CITY OF ALBUQUERQUE

June 14, 2021

Re: Cien Aguas Charter School
2501 Buena Vista Dr SE
Traffic Circulation Layout
Engineer's Stamp 06/08/2021 (M15-D004B)

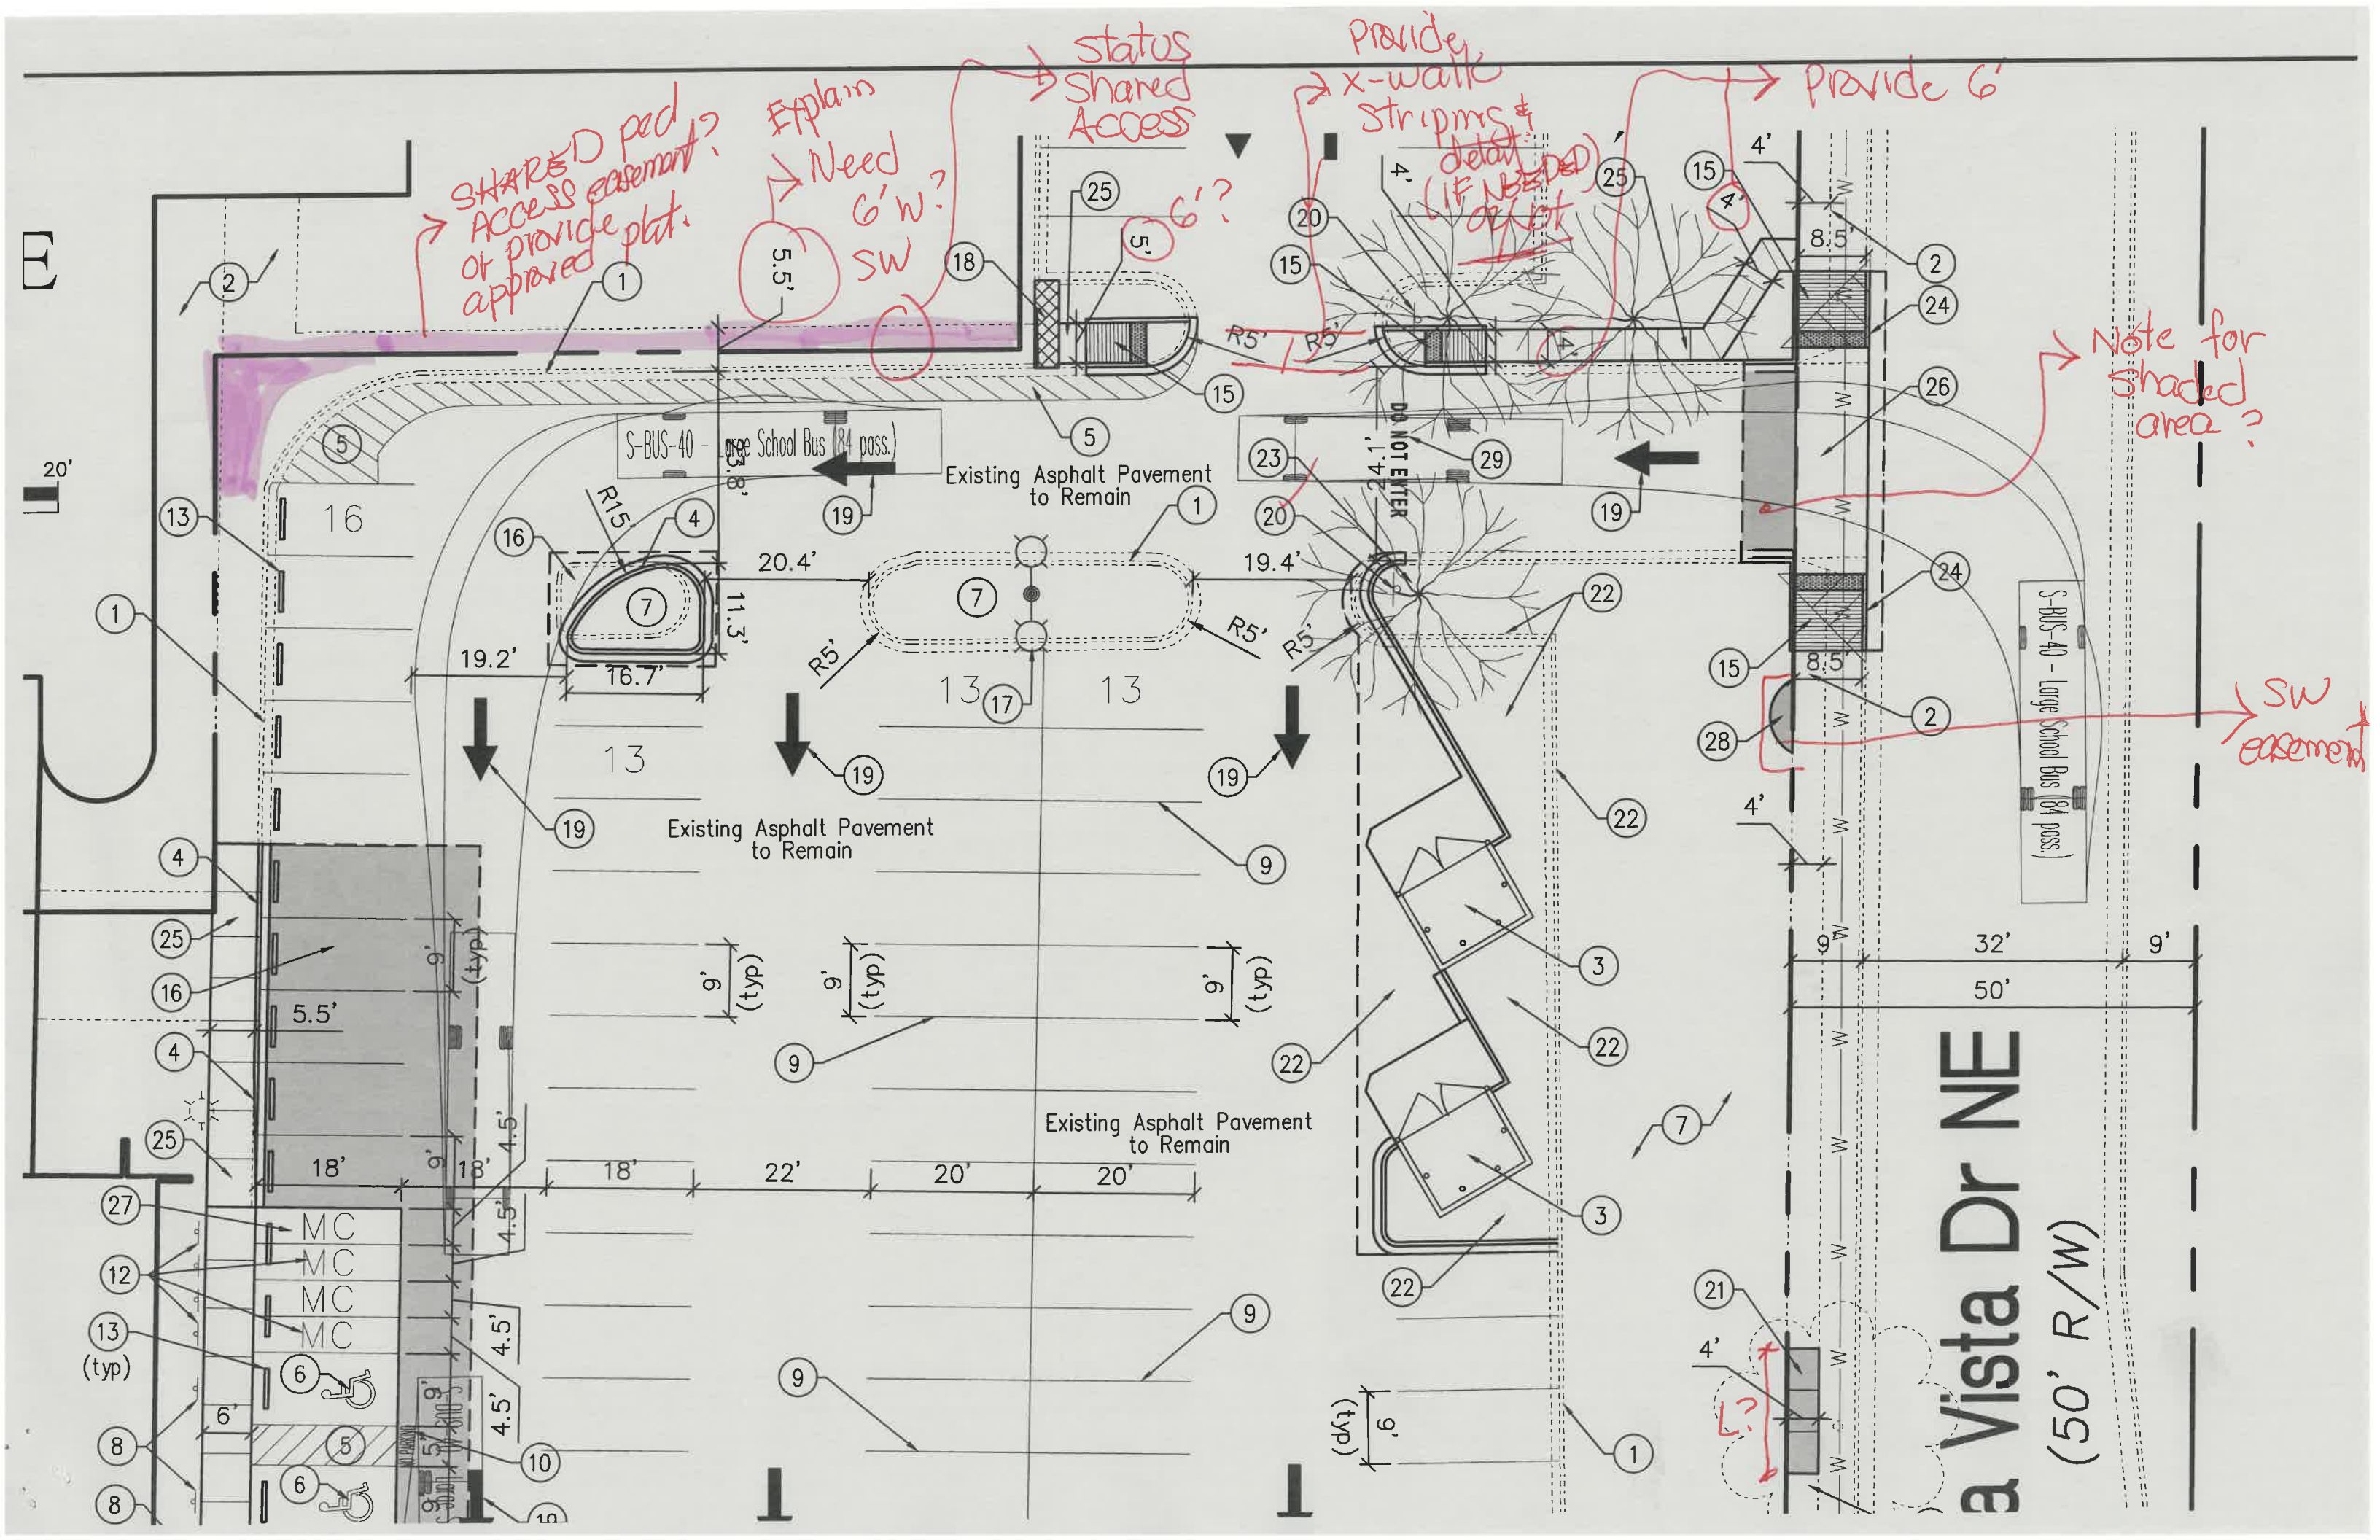
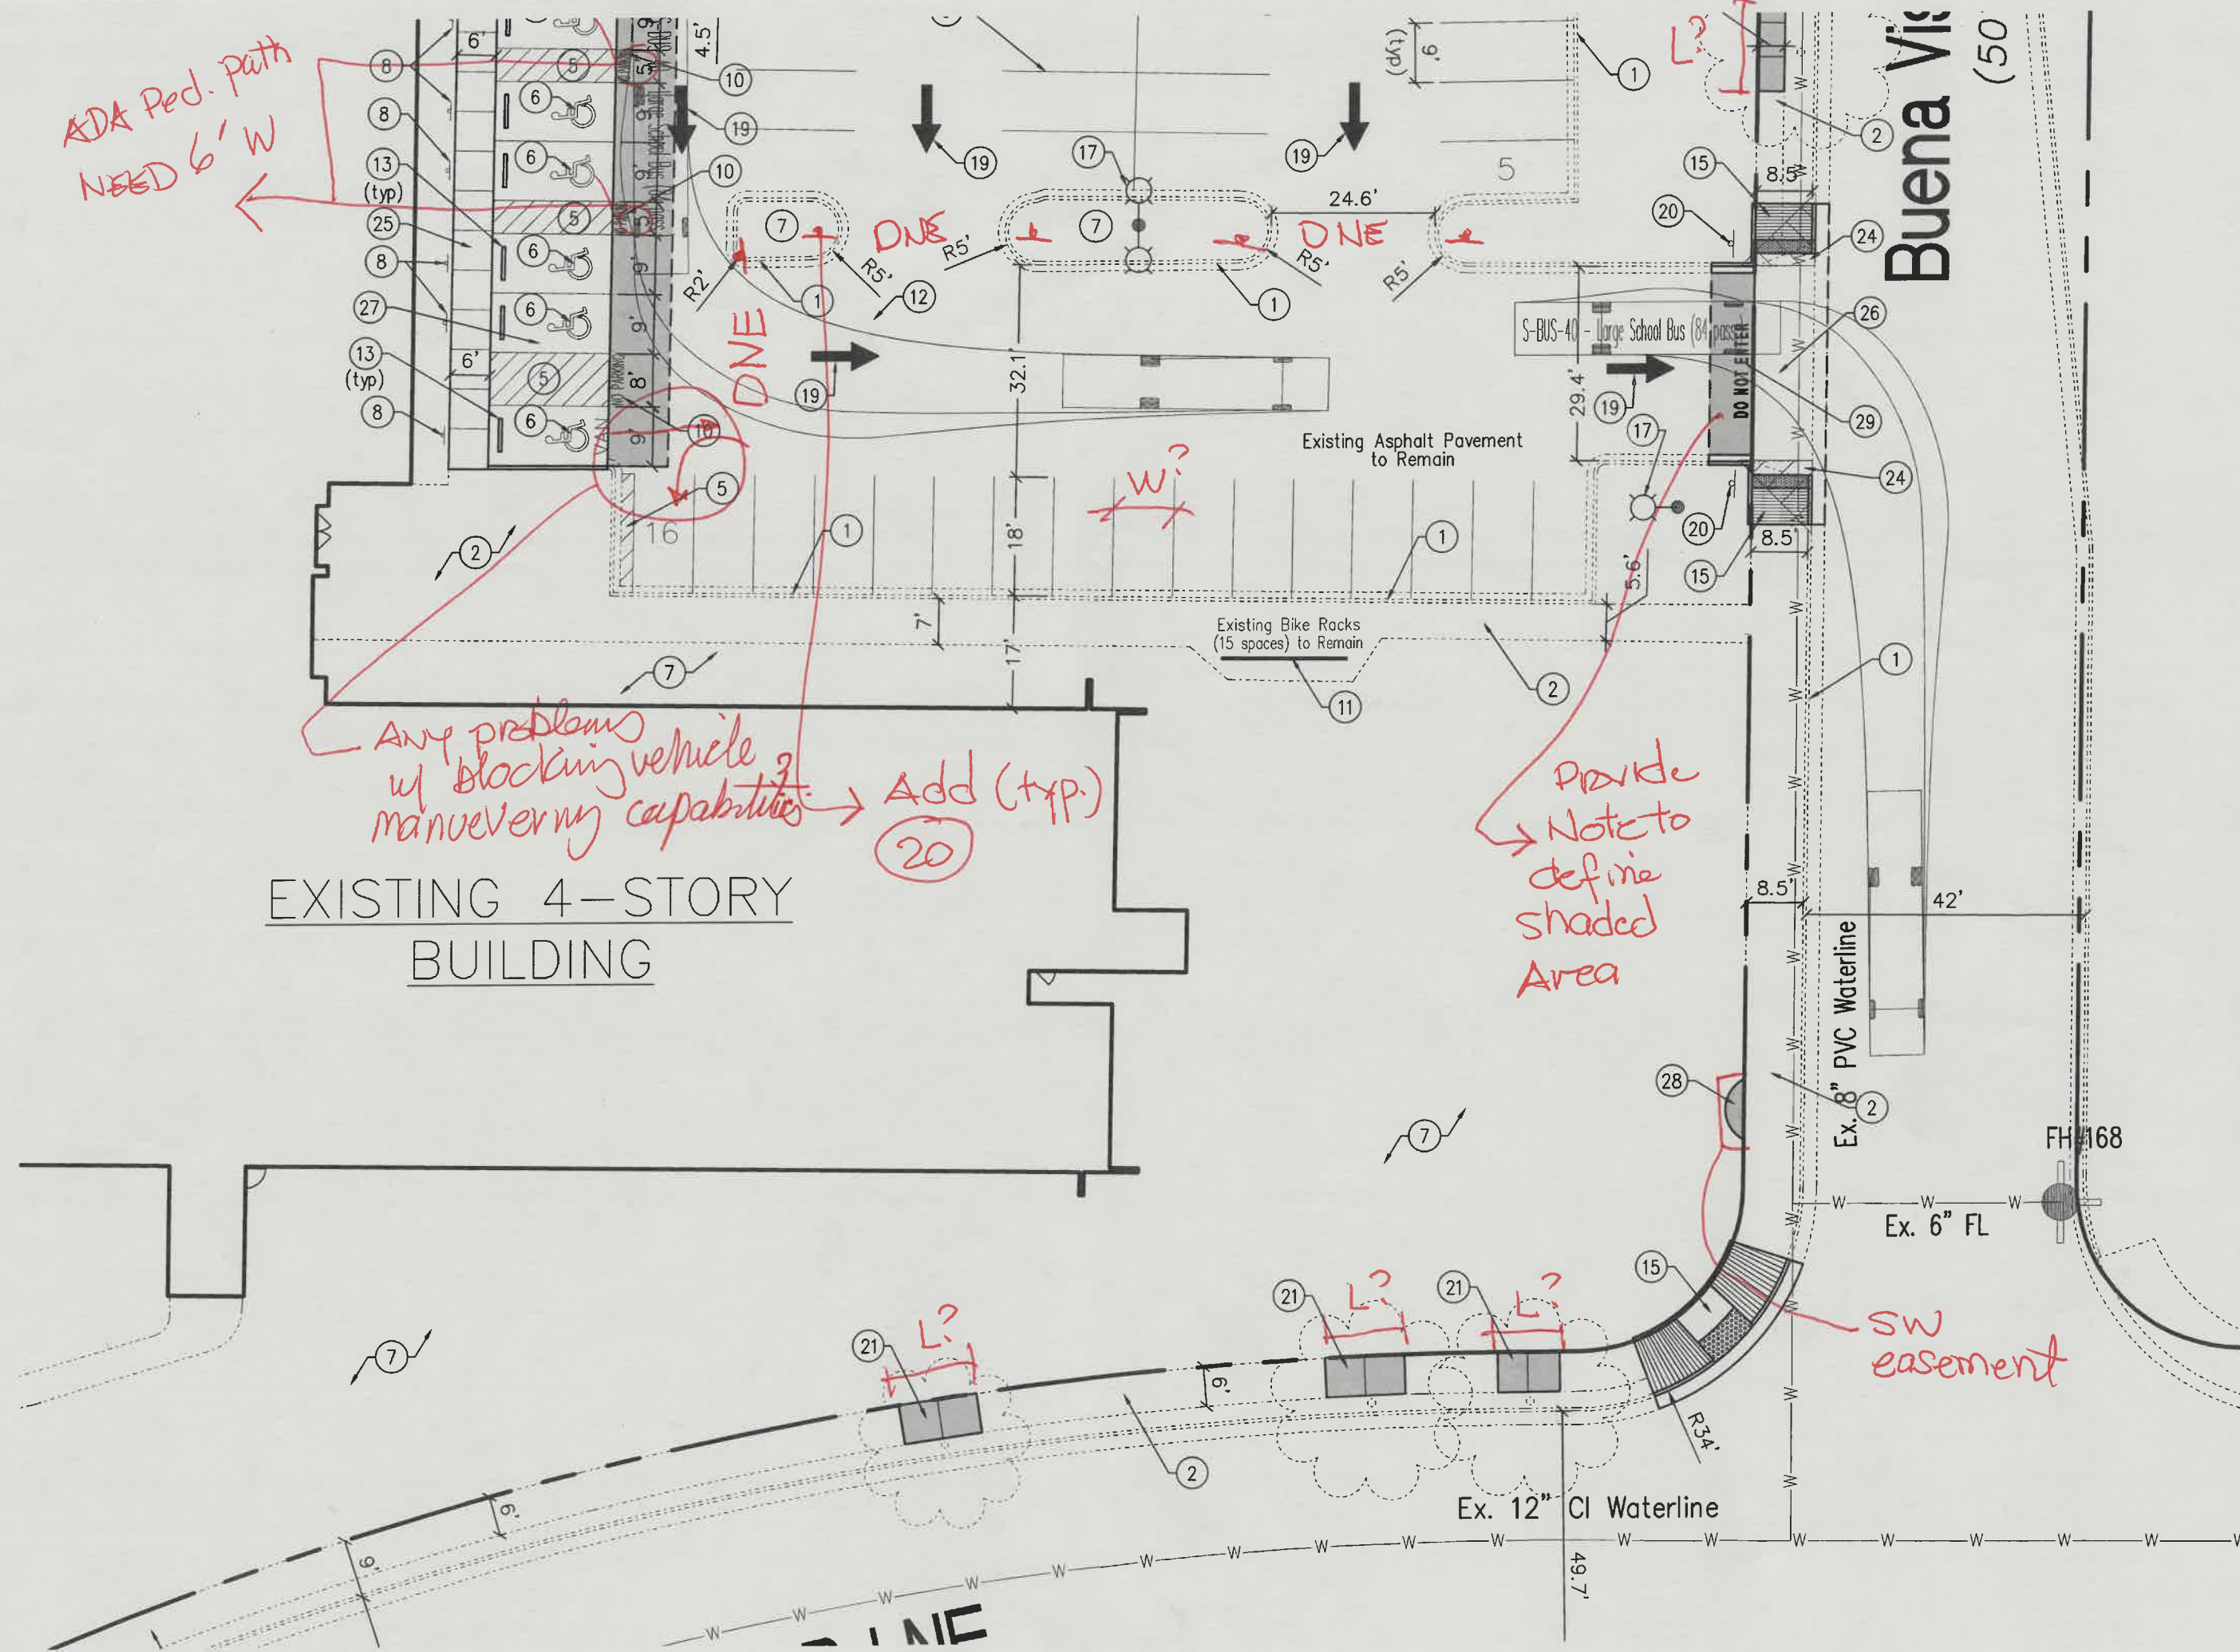
2. **All existing driveways/pads fronting Randolph Road and Buena Vista Drive are not ADA accessible. You will need to replace these drivepads to comply with the most current/updated design (Reference COA std dwg 2425A&B).**

3. **Buena Vista Drive existing Driveway(Adjacent to to 10 ft wide Concrete Channel):**
 - **Provide the drive aisle width and sidewalk width along side of the drive aisle (sidewalk was not shown on site plan).**

- **The adjacent ramps adjacent to drive aisle will need to be ADA complaint.**
4. **A turning template for a vehicle is shown for ingress and egress movement. What is vehicle size?**

5. **The existing striping and pavement markings onsite are faded (includes ADA parking pavement markings) will need to be restriped. All ADA pavement markings outside of the parameters of parking stalls will need to be eradicated. Please follow the MUTCD guide for the pavement markings and striping.**

6. **Details are required for all proposed striping and pavement markings on site.**
7. **Identify all existing access easements and rights of way width dimensions.**

8. **Identify the right of way width, medians, curb cuts, and street widths on Randolph Road and Buena Vista Drive.**
9. **Maximum access width for arterial, collector, and local streets (Buena Vista Drive) are as follows:**

10. Grades and slopes in the parking area and/or the ADA accessible parking and 6ft pedestrian pathway from public to building entrance areas appear to be too large. Please provide more detail.
11. Please list the width and length for all existing and proposed parking spaces. Some dimensions are not shown (especially ADA parking stalls).
12. The minimum parking stall dimensions need to be followed and labeled per the table below:

14. The ADA accessible spaces must include an access aisle. Van accessible aisles should be 8ft wide; all others should be 5ft wide.
15. The ADA accessible parking sign must have the required language per 66-7-352.4C NMSA 1978 "Violators Are Subject to a Fine and/or Towing." Please call out detail and location of signs. At present time, all ADA stalls don't have any type of signage and will need to be provided. The signage and post design will need to follow MUTCD guidelines.

16. The ADA access aisles shall have the words "NO PARKING" in capital letters, each of which shall be at least one foot high and at least two inches wide, placed at the rear of the parking space so as to be close to where an adjacent vehicle's rear tire would be placed. (66-1-4.1.B NMSA 1978). All existing ADA stalls pavement markings/stripping are faded and will need to be restriped and details provided.

17. ADA curb ramps must be updated to current standards and have truncated domes installed at the corner of Randolph/Buena Vista and Buena Vista/Renard Pl. Construction notes and details will need to be provided.

18. Buena Vista Drive existing utility posts have impacted sidewalk widths for passenger. Provide a sidewalk transition/obstruction detail per COA std dwgs 2431 & 2432.

23. Show all drive aisle widths and radii. Some dimensions are not shown.
24. The minimum drive aisle dimensions are shown below:

25. List radii for all curves shown; for passenger vehicles. Radius for delivery trucks, fire trucks, etc. is 25 ft. or larger.
26. Per the IDO, a 6 ft. wide ADA accessible pedestrian pathway is required from the public sidewalk to the building entrances (please clearly show this pathway and provide details) There is an existing 5 ft sidewalk from Buena Vista Drive but the longitudinal grade is an average of 6%. This will need some type of ADA design to address this steep slope. Please clearly show this pathway and provide details.

27. Per DPM, a 6 ft. wide ADA accessible pedestrian pathway is required from the ADA parking stall access aisles to the building entrances. Please clearly show this pathway and provide details.

28. Parking areas shall have barriers to prevent vehicles from extending over the 6ft wide ADA accessible sidewalk/pathway from ADA parking stall aisles to building entrance. The existing sidewalk fronting these stalls are only 54 inches and with 2

29. **Parking barriers will be needed for this first 5-6 stall from the building entrance because the sidewalk is flush with the parking stalls and is a safety concern for the ADA pedestrian pathway.**

30. **ADA accessible pedestrian pathway should not be placed behind parking space or adjacent to a vehicular way. Vehicle and pedestrian/wheel chair conflicts should be avoided as much as possible.**

31. **All sidewalks along streets: Provide existing widths.**
32. **Show the location of solid waste container and provide a copy of refuse approval.**
33. **It is not apparent what type of pavement surface is being proposed and/or existing. A hard driving surface will be required as part of this proposed project for parking area and drive aisles.**

34. **All one-way drives shall have "One Way" and "Do Not Enter" signage and pavement markings. These signs will need to follow MUTCD. Please provide the sign face and pavement marking details.**

35. **Please provide a sight distance exhibit**
36. **Show the clear sight triangle and add the following note to the plan: "Landscaping and signage will not interfere with clear sight requirements. Therefore, signs, walls, trees, and shrubbery between 3 and 8 feet tall (as measured from the gutter pan) will not be acceptable in the clear sight triangle.**

39. **Sidewalk widths within the public right of way and on site will need to be provided.**
40. **Add a note stating "All broken or cracked sidewalk must be replaced with sidewalk and curb & gutter." A build note must be provided referring to the appropriate City Standard drawing (2430 & 2415).**

41. **Sidewalk frontage off Randolph Road and Buena Vista Drive has been raised/buckled by tree roots. The sidewalk segments impacted will need to be replaced per COA std dwg 2430**
